Application No: P/178/21/OUT  
Site Address: Land West of Pagham Road Pagham  
Description of works: Outline application with all matters reserved (except access) for the construction of up to 106 new homes, formation of access onto Pagham Road, new pedestrian and cycle links, the laying out of open space, new strategic landscaping, habitat creation, drainage features and associated ground works and infrastructure. This application is a Departure from the Development Plan and may affect the setting of a Listed Building.

Thank you for your internet representation made on 3rd March 2022 which has been recorded as an objection with the comments as follows:

Figure 5: Site Access Arrangement

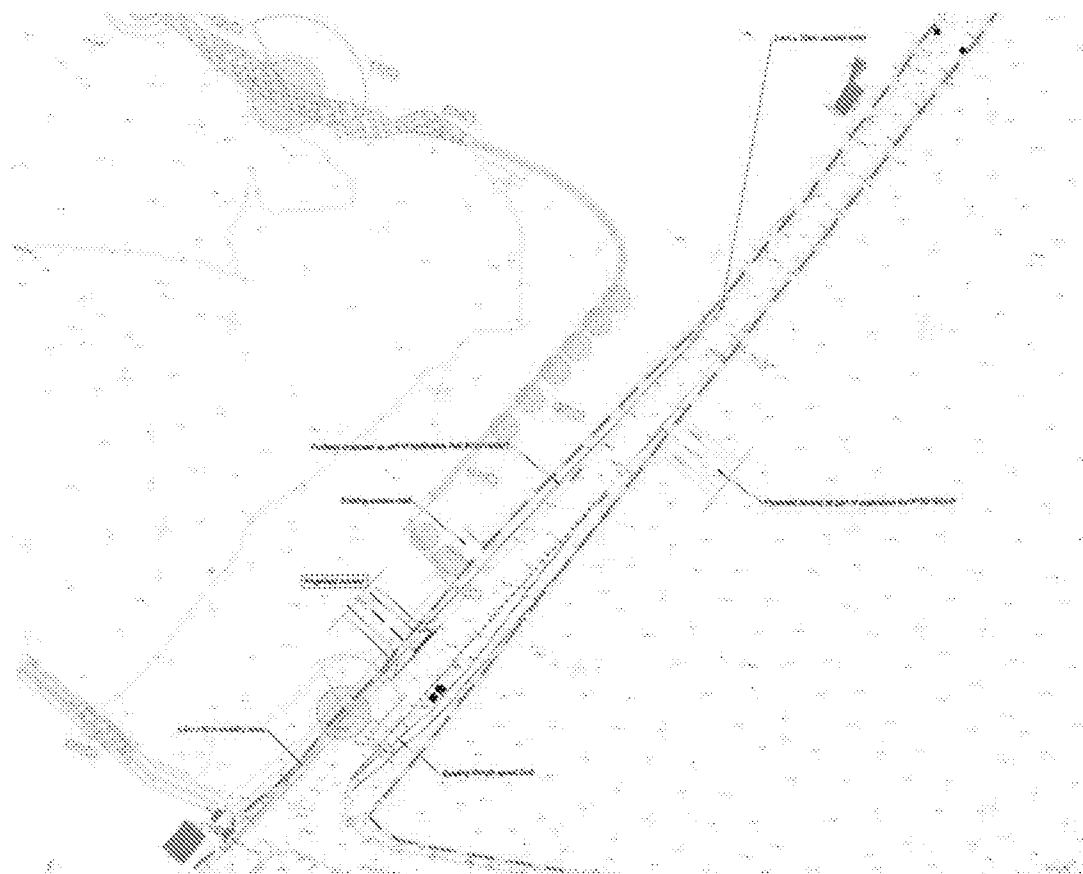
Further to my previous comment, I just want to question the Access Arrangements that are a reserved matter on this application. The comment from WSCC Highways states that "The site is proposed to be accessed via a new priority junction on Pagham Road. Although the access lies within the 30mph speed limit, this changes to the National Speed limit to the immediate north".

However, this is not true The Access lies in the national speed limit area, NOT the 30 mph zone. This is clearly seen from either a) visiting the site or b) looking at the access arrangements drawing as provided in the application.

I am concerned that as the WSCC Highways team been aware of this, they may have concluded differently on what the appropriate visibility splays are.
